**KIRKLEES METROPOLITAN COUNCIL
INVESTMENT & REGENERATION SERVICE**

Reference No:	2024/62/93589/E
Site Address:	26, Hare Park Lane, Hightown, Liversedge, WF15 8DQ
Description:	Erection of single storey front extension
Recommending Officer:	Faiza Bano

DECISION – REFUSE

Officer Report

Proposed extension

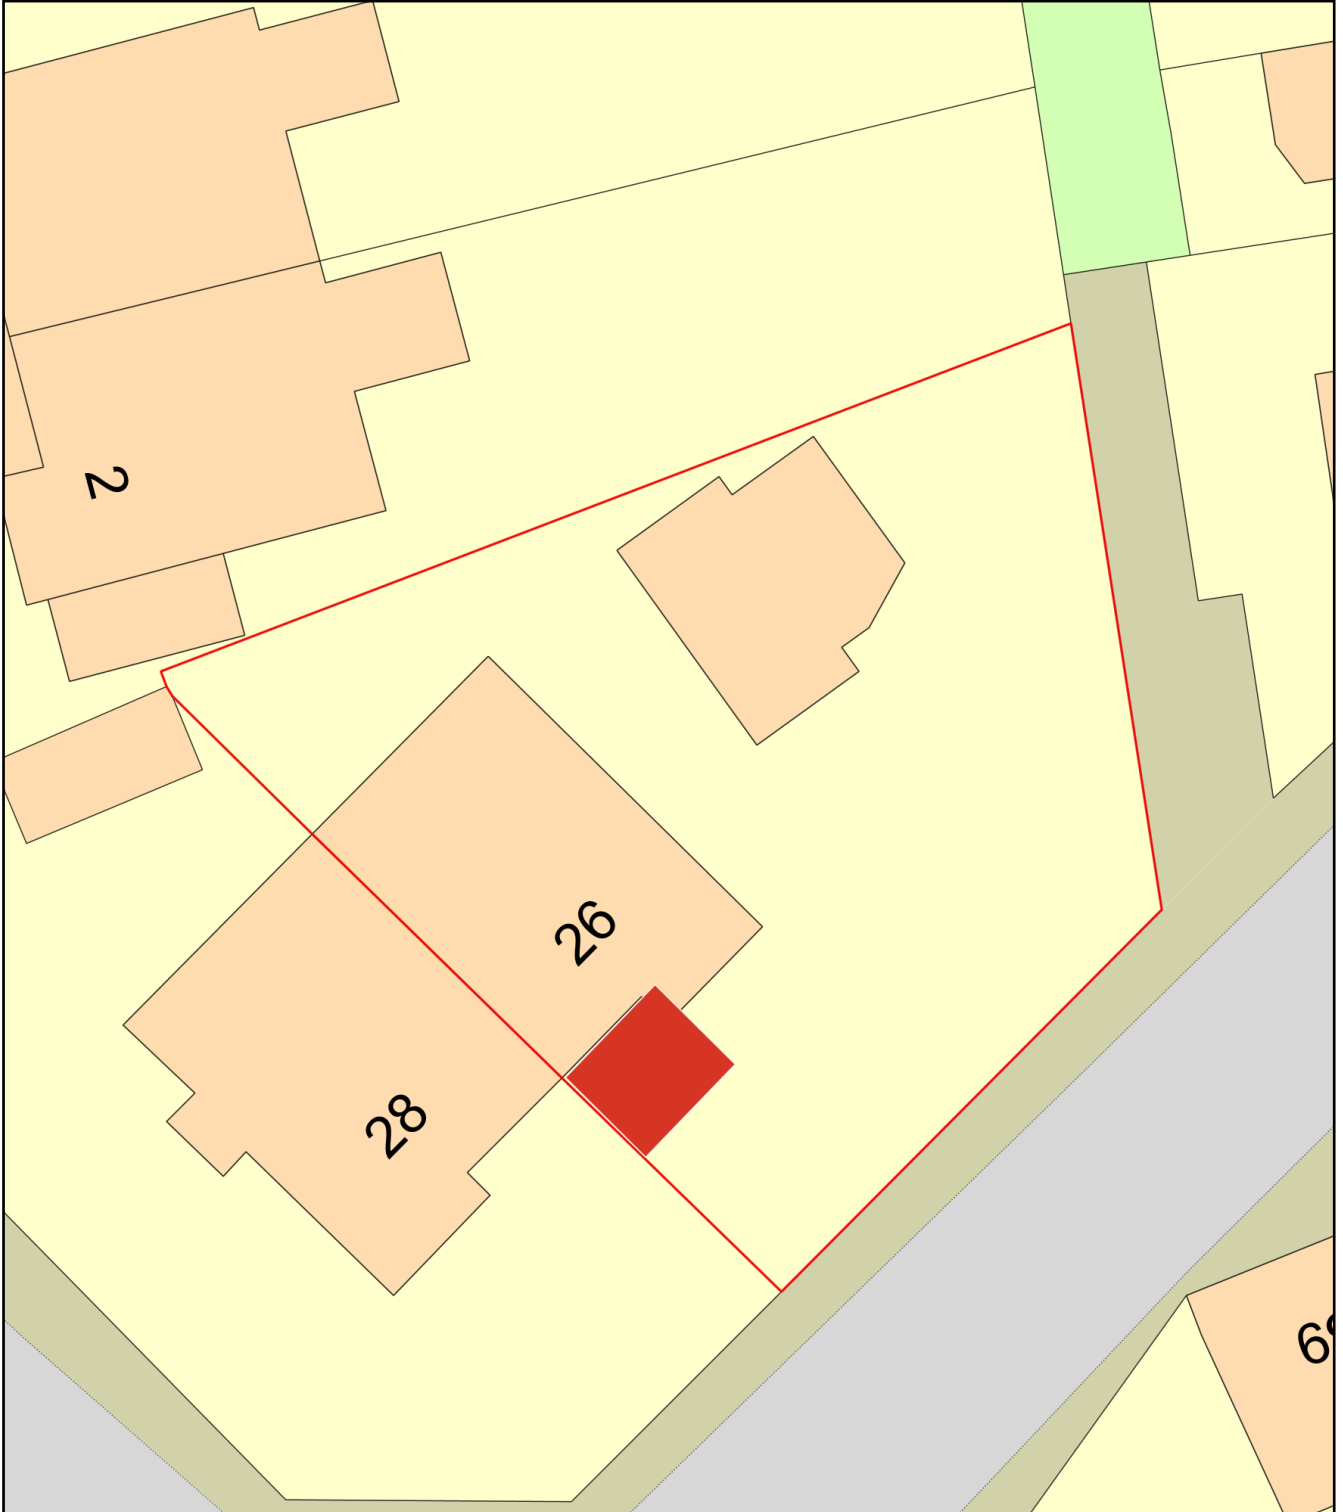
the host. The extension would be set back 5 metres from the highway and would be constructed from stone to match the host property.

PROPOSED EXTENSION
Plans as proposed

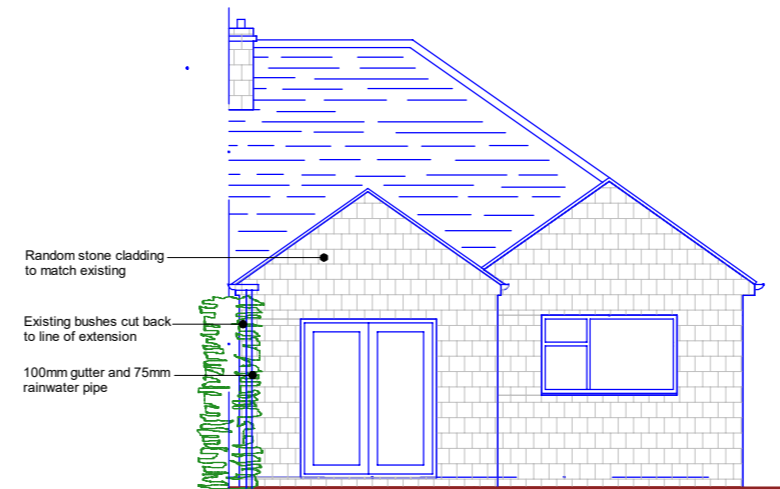
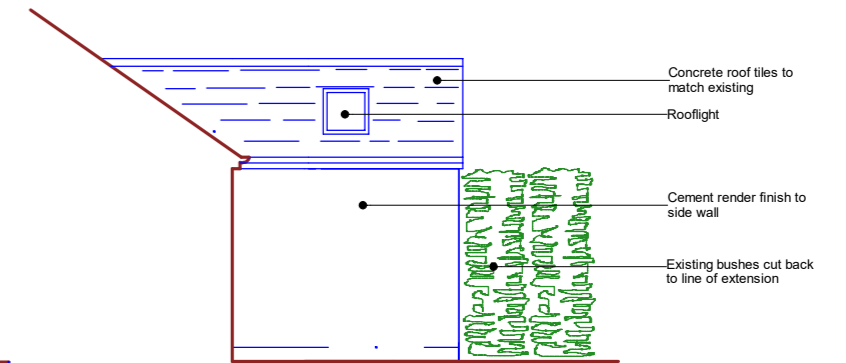
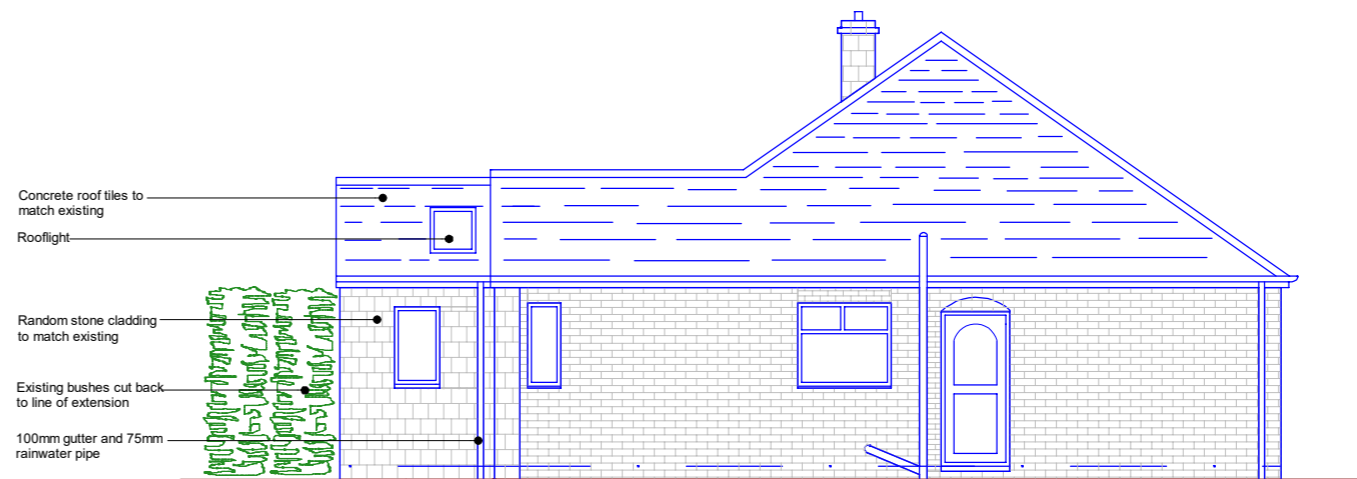
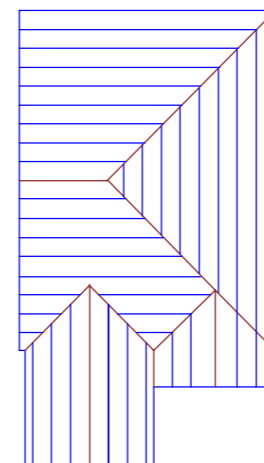
The proposal would project 3 metres beyond the front elevation and shared building line with the adjoining bungalow and 2.4 metres beyond the front wall of the single storey section of the host dwelling and extend across the front of

It is considered that the extension is not small or subservient to the front of the property and would appear as an unsympathetic alteration to the host dwelling. Whilst the property is set back from the highway, due to the scale and positioning, the extension would be visible within the street scene. The site is one of a pair of symmetrical dwellings and, due to its scale, the extension would detract from the character. As such, the proposed works are considered not to be acceptable, as it would substantially alter the character of the original dwelling and form an incongruous feature within the locality.

The extension is designed with a pitched roof similar to the existing single-storey projection. Considering the prominence of this extension at the front of the dwelling, it is considered that the projection and design would not appear sympathetic or in keeping with the character of the original house. It is noted that the materials proposed would match the host. However, the overall concerns in terms of the scale and design would result in an extension which is not subservient, nor would it be in keeping with the character of the host property or the wider street scene.

It is therefore considered that, the proposal by reason of its scale and projection and prominence would fail to respect the character of the host dwelling and would be a harmful addition within the street scene and wider area. Therefore, it is considered that in terms of visual amenity, the proposed would not comply with Policy LP24 of the Kirklees Local Plan, the Key Design Principles 1 and 2 in the House Extensions and Alterations SPD, and advice within the National Planning Policy Framework.

- **28 Hare Park Lane** – This property is the adjoining bungalow which has openings within the front elevation.
- Due to the location, projection and height of the proposed scheme, the extension would have an overbearing and overshadowing impact to the detriment of the occupants of this property. Due to the 3 metre projection along the shared boundary with the neighbour the extension would not meet the requirement of the 45 degree requirement as set out in the House Extensions and Alterations SPD, preventing natural light from entering the habitable room closest to the boundary and causing detrimental harm to the occupants. The loss of natural light would necessitate increased reliance on artificial lighting, impacting the residents' quality of life. Additionally, the scale and massing of the extension would dominate the garden space, creating a cramped and shaded environment that is not in keeping with the character of the surrounding area. The proposed materials, while matching the host property, do not mitigate the adverse effects on the occupants of the neighbouring property.

1. The proposed development, by reason of its design and scale, would appear prominent and unsympathetic in relation to the original host dwelling, resulting in a discordant addition that detracts from the street scene and wider area, to the detriment of visual amenity, contrary to Policy LP24 of the Kirklees Local Plan, Key Design Principles 1 and 2 in the House Extensions and Alterations SPD, and advice within the National Planning Policy Framework.

1. The proposed development, by reason of its scale and proximity to the neighbouring property, 28 Hare Park Lane, would result in an overbearing/overshadowing impact, resulting in loss of light and outlook to the detriment of the residential amenity of the occupants, contrary to Policy LP24 of the Kirklees Local Plan, Principles 3, 4, 5 and 6 of the adopted House Extensions and Alterations SPD, and advice within Chapter 12 of the National Planning Policy Framework.
